Please ask for: Jonny Cooper
Email: jonny.cooper@arun.gov.uk
Telephone: 01903 737532
Our Ref: BR/187/24/PL
Your Ref:
Date: 1st October 2024

Application for Planning Permission

Development: Conversion & Change of Use of Single Storey Former Printers Workshop to Form 2-Bed Dwelling with Cycle Parking & Refuse Storage Facilities.
Location: 47 Aldwick Road Bognor Regis PO21 2NJ

Drawing Number 2024/64 Sheet 2 of 3
Size A1 Scale 1:50, 1:100, 1:500, 1:1250

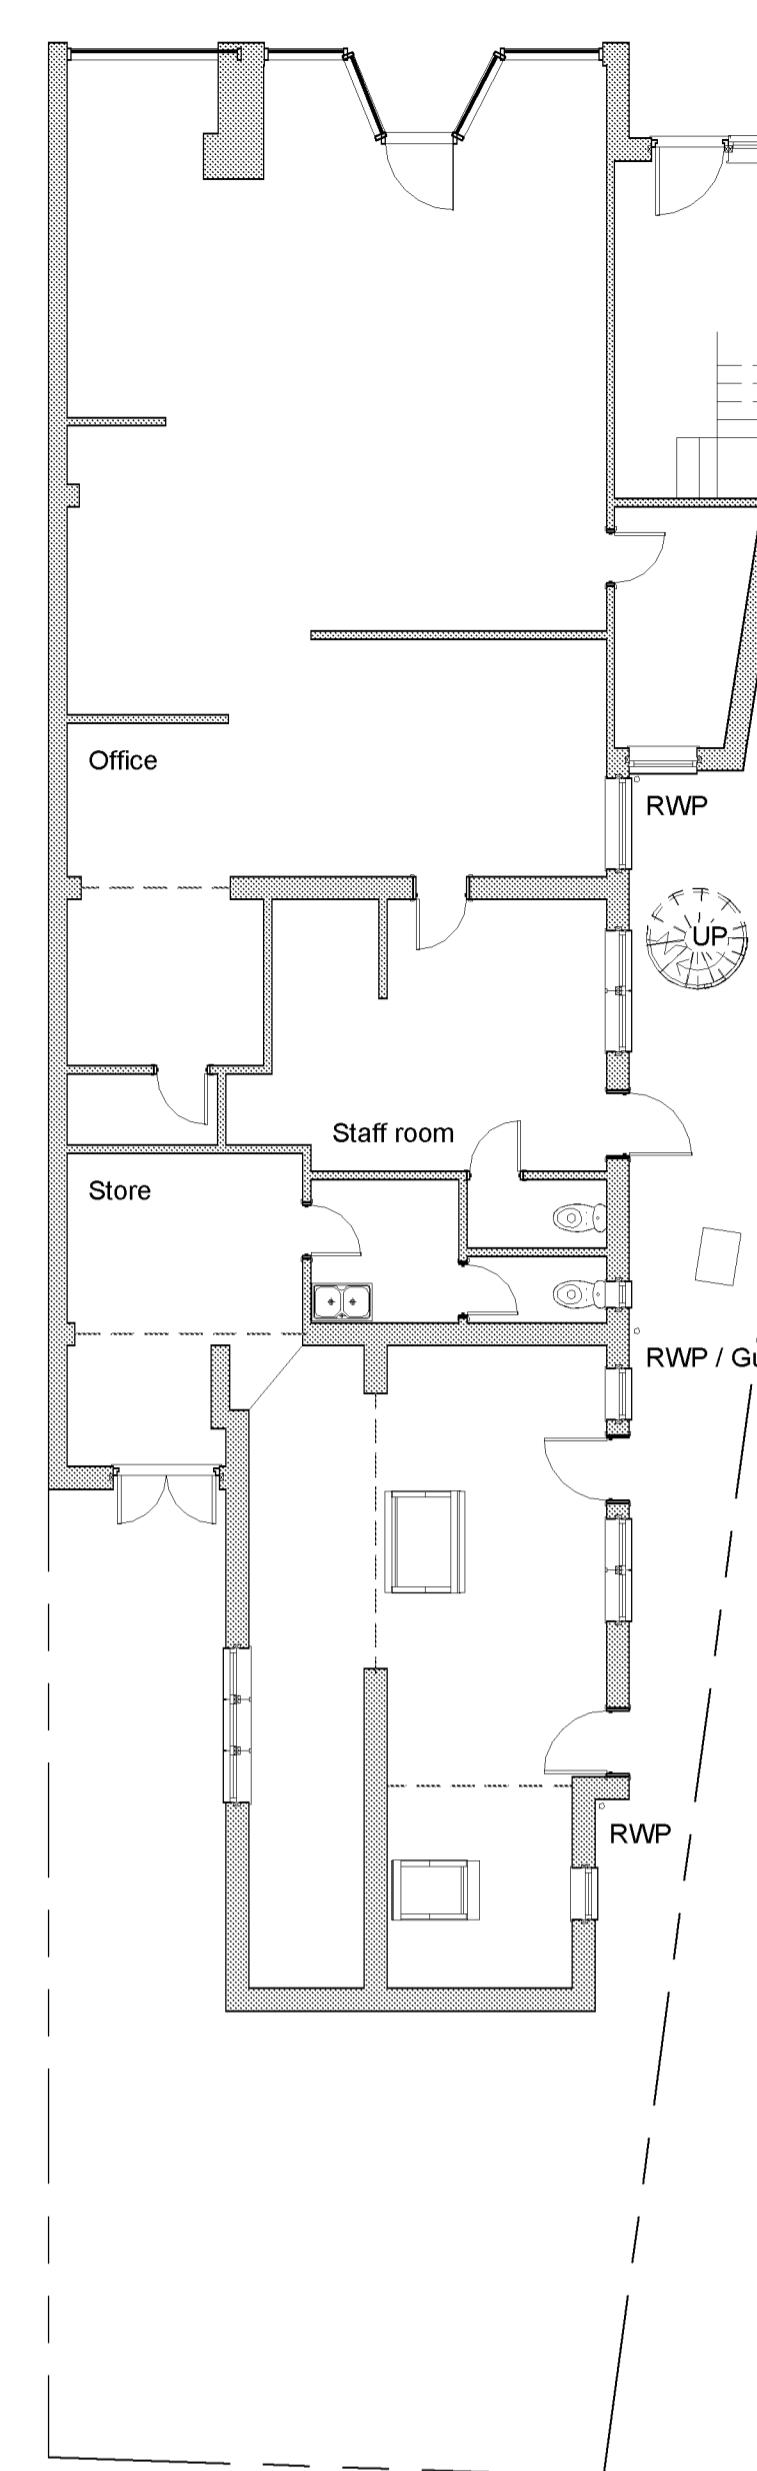
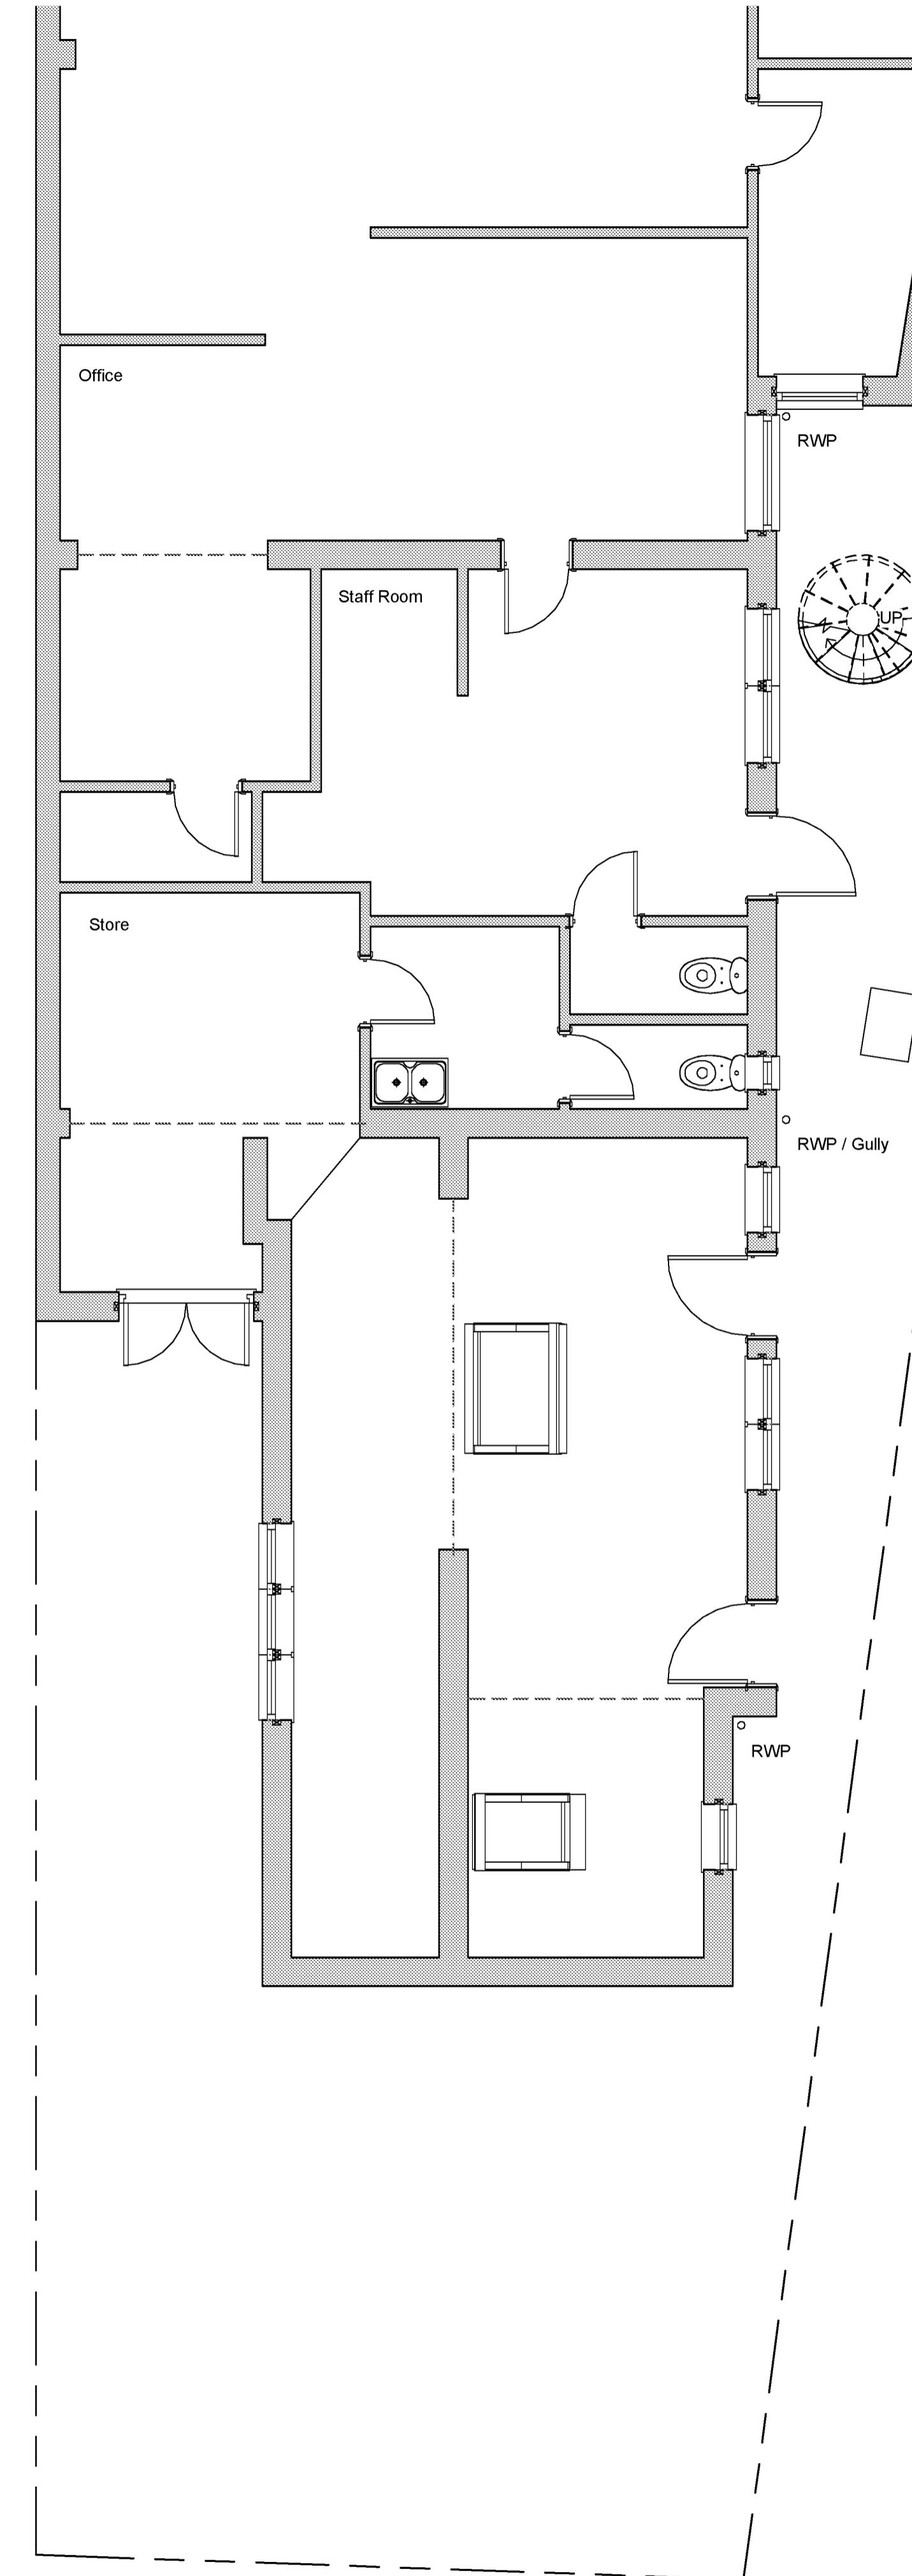
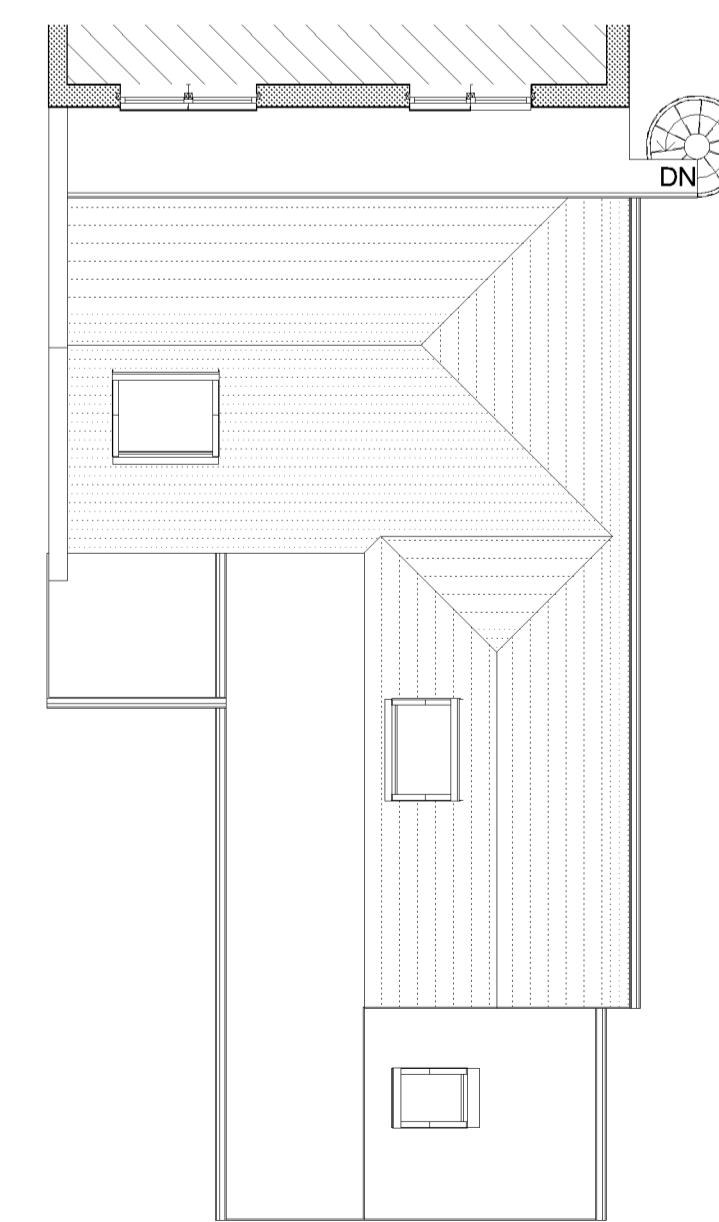
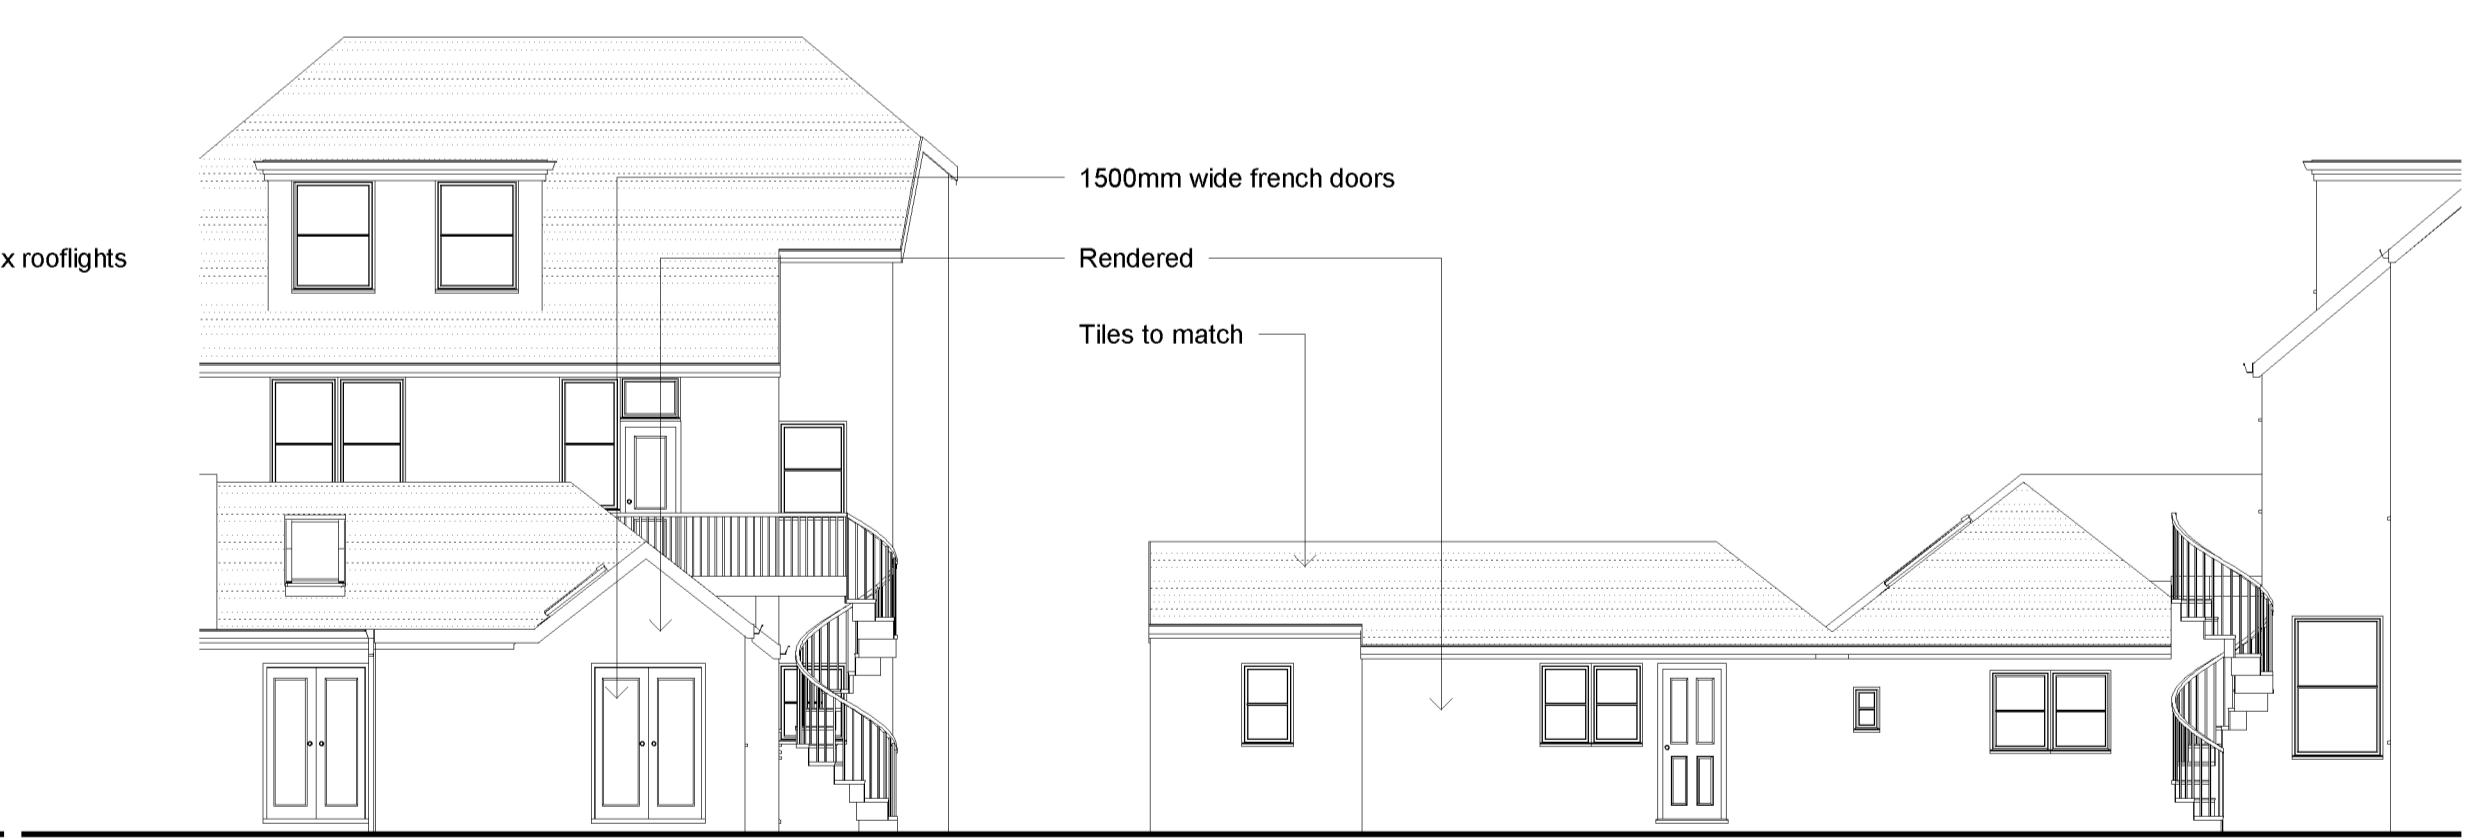
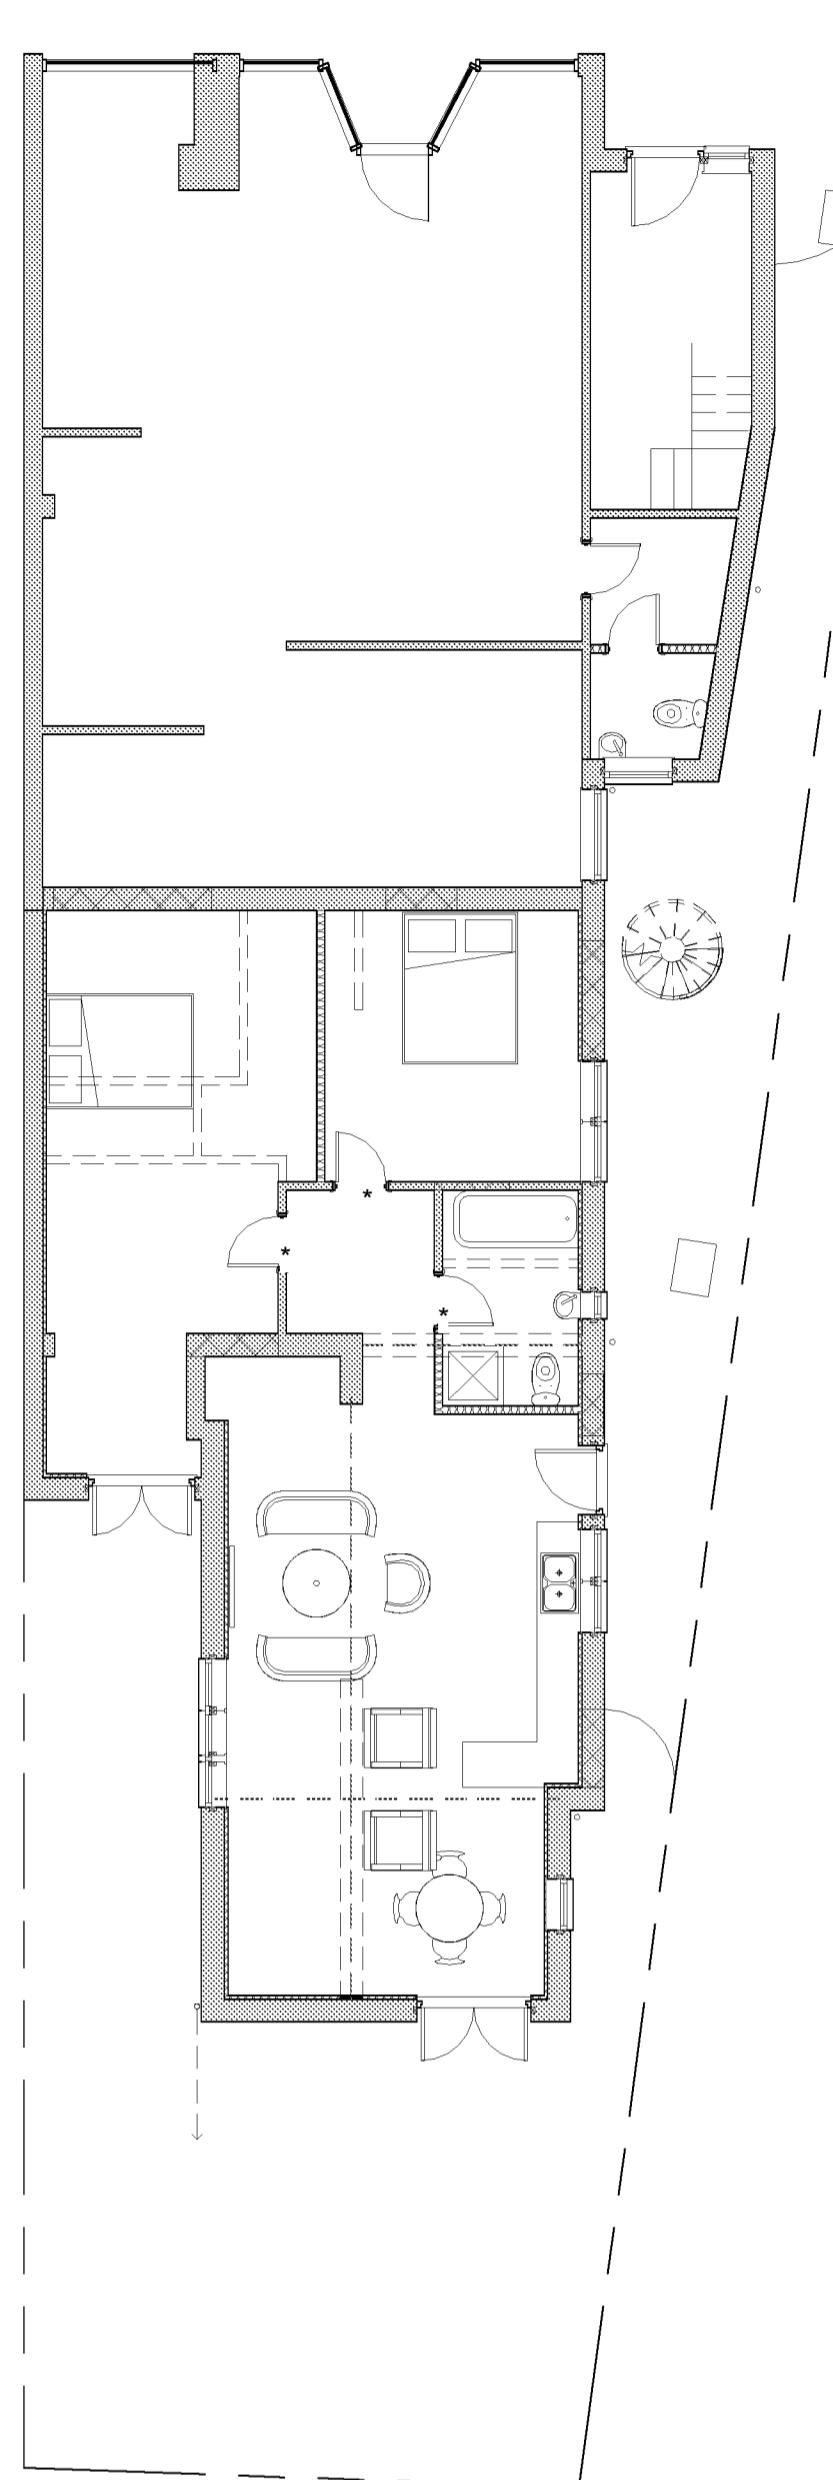
All the scale bars on the plans provided (other than the cycle and bin store plans) scale at half the indicated length. Please amend accordingly and resubmit.
